OUT16/27880

**Mount Owen Continued Operations Project (SSD 5850)
Glencore Response to Commission Review Report**

I refer to your email of 1 June 2016 requesting a review of the Glencore's (the Proponent) response to the Planning Assessment Commission's (PAC) Review Report for the Mount Owen Continued Operations project (the Project).

**FIGURE 2.12**  
**Proposed Mount Owen**  
**Conceptual Mine Plan**  
**Final Landform**

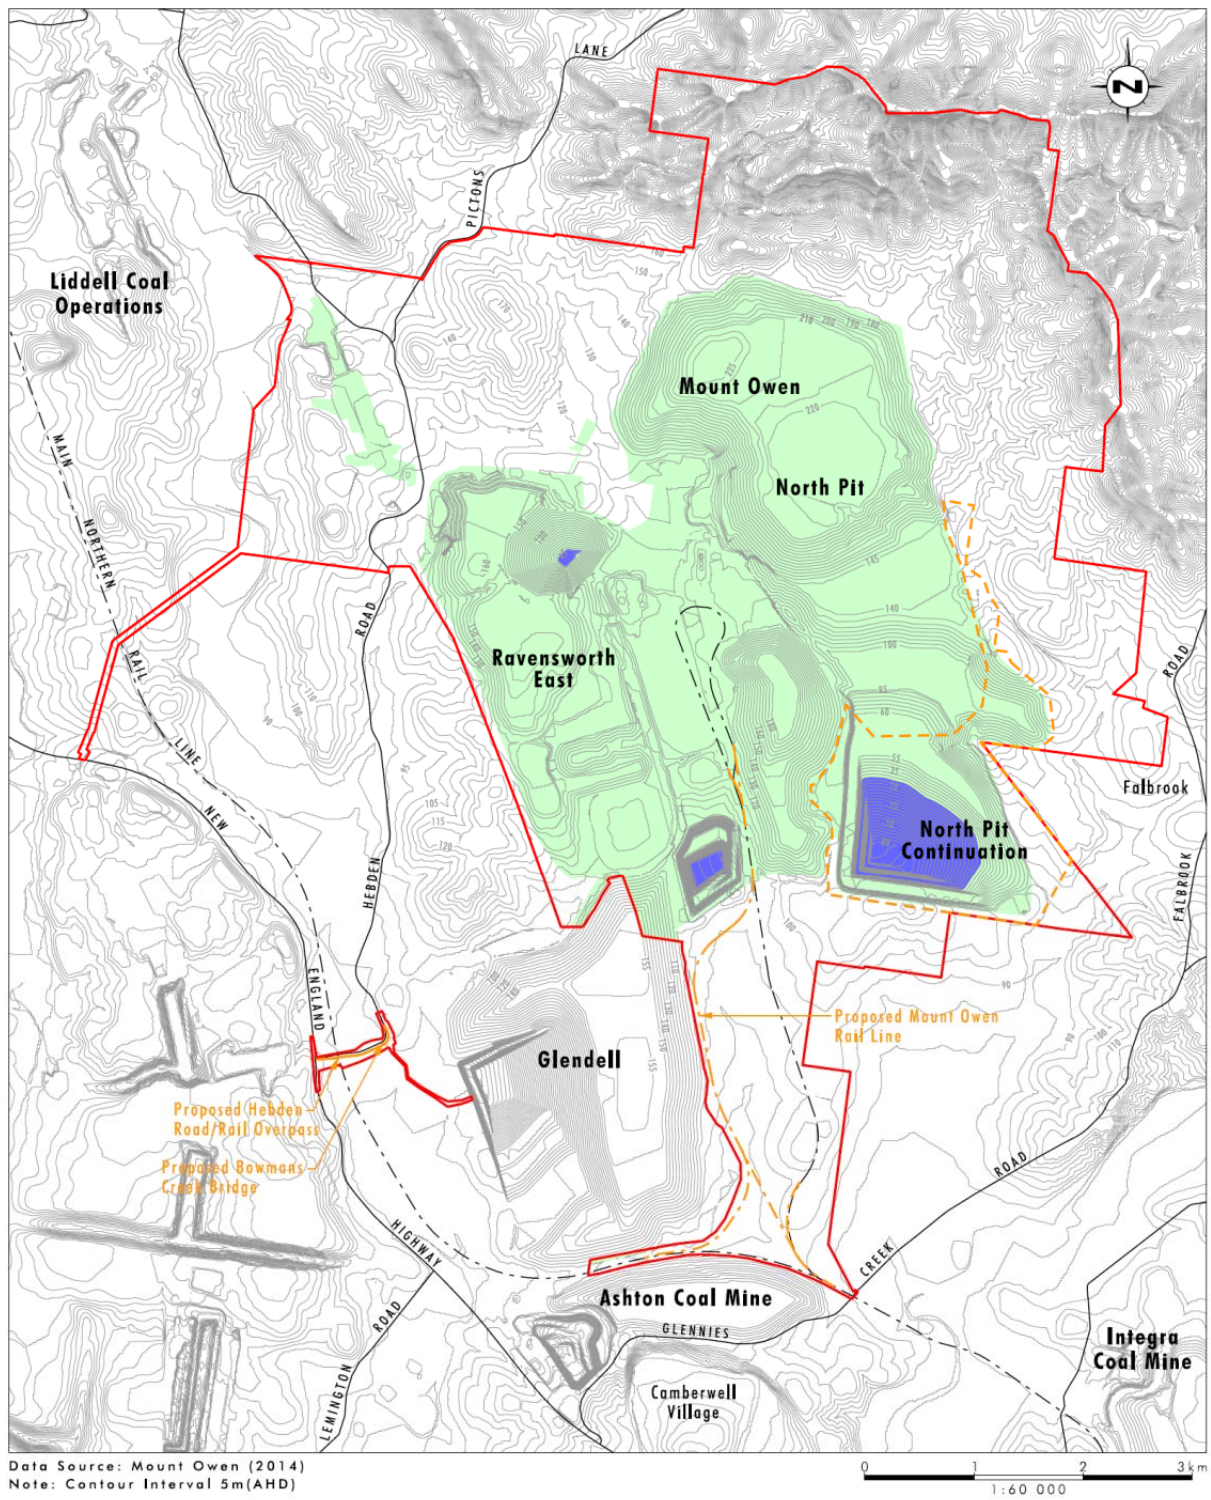
The applicant has proposed a reduction in the number of final voids from three voids to two voids. The Division supports the reduction in the number of final voids as proposed by the Proponent as it results in an increase of beneficial land use on mine closure. The altered locations of final voids are to be included in revisions of the Rehabilitation Management Plan (RMP), also known as a Mining Operations Plan (MOP) under a Mining Lease.

Compared to the EIS, the proposed modifications result in one less void and a reduction of 12 ha of void catchment and 6 ha of pit lake area. The Division considers the reduction in void catchment and pit lake area compared to that proposed in the EIS as an improvement in mine closure outcomes.

## APPENDIX 7 REHABILITATION PLAN

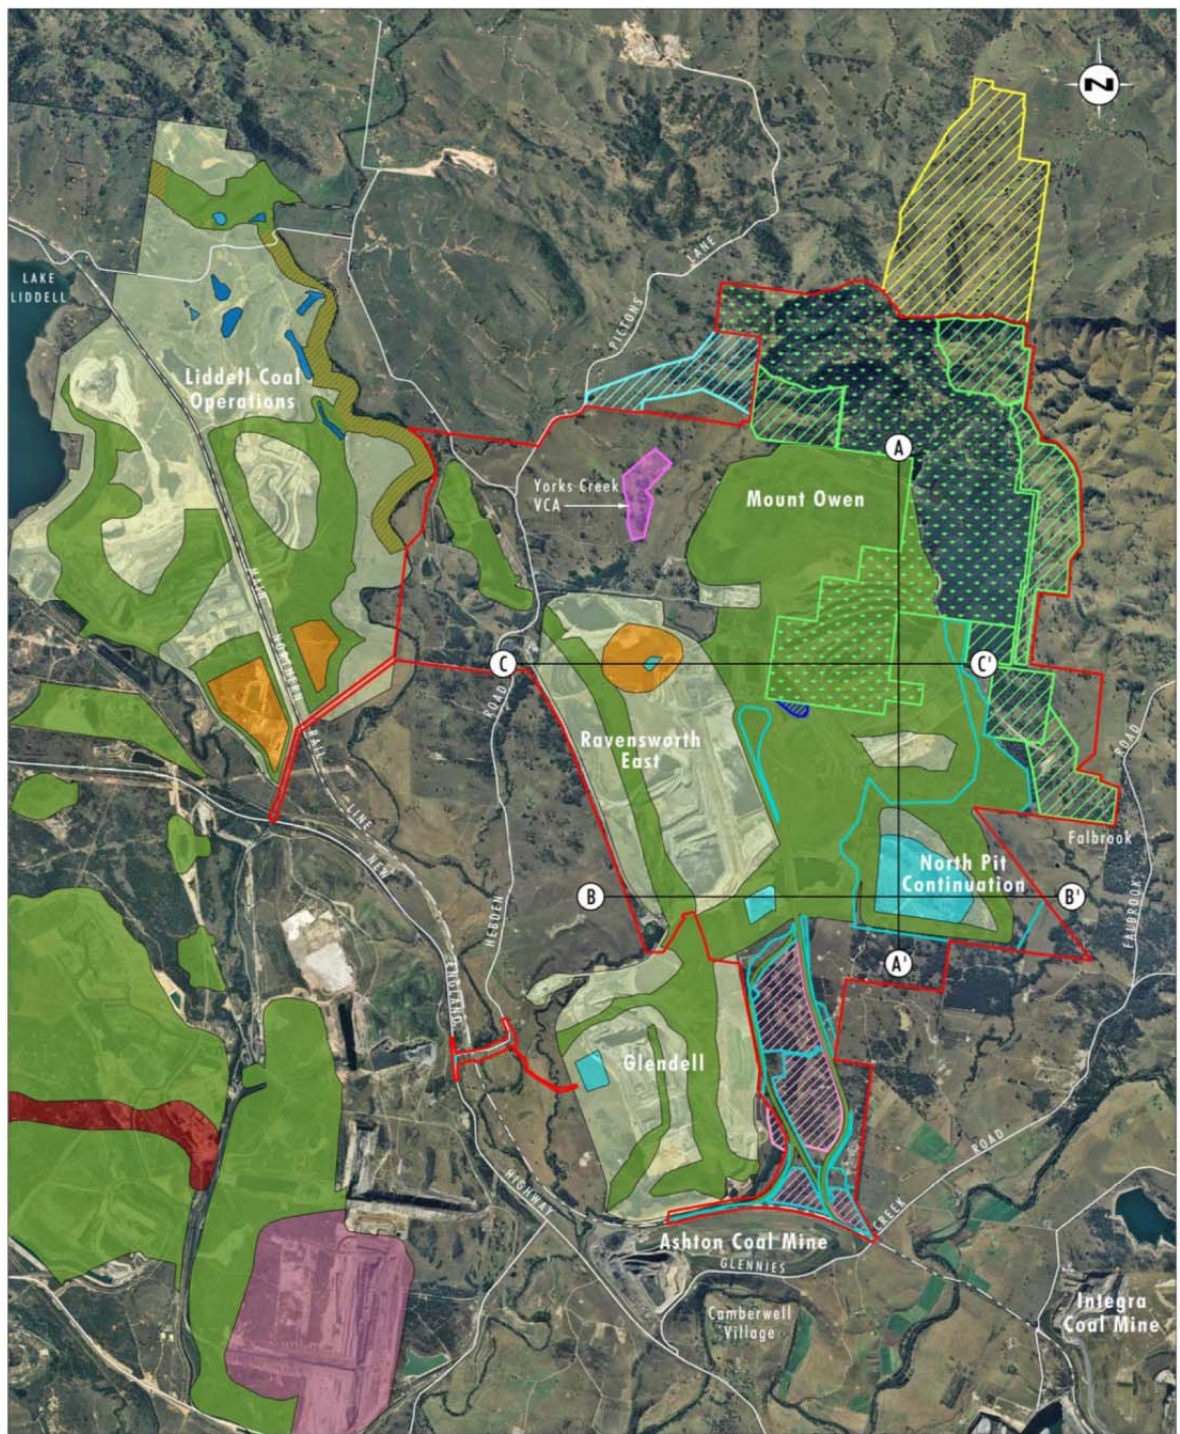
The assessment of potential land uses has been revised with consideration of the new final landform. Woodland has been increased and the area for grazing reduced. The Division considers this is appropriate to ensure long-term land uses can be achieved. The changes in land use objectives are to be incorporated into revisions of the MOP.
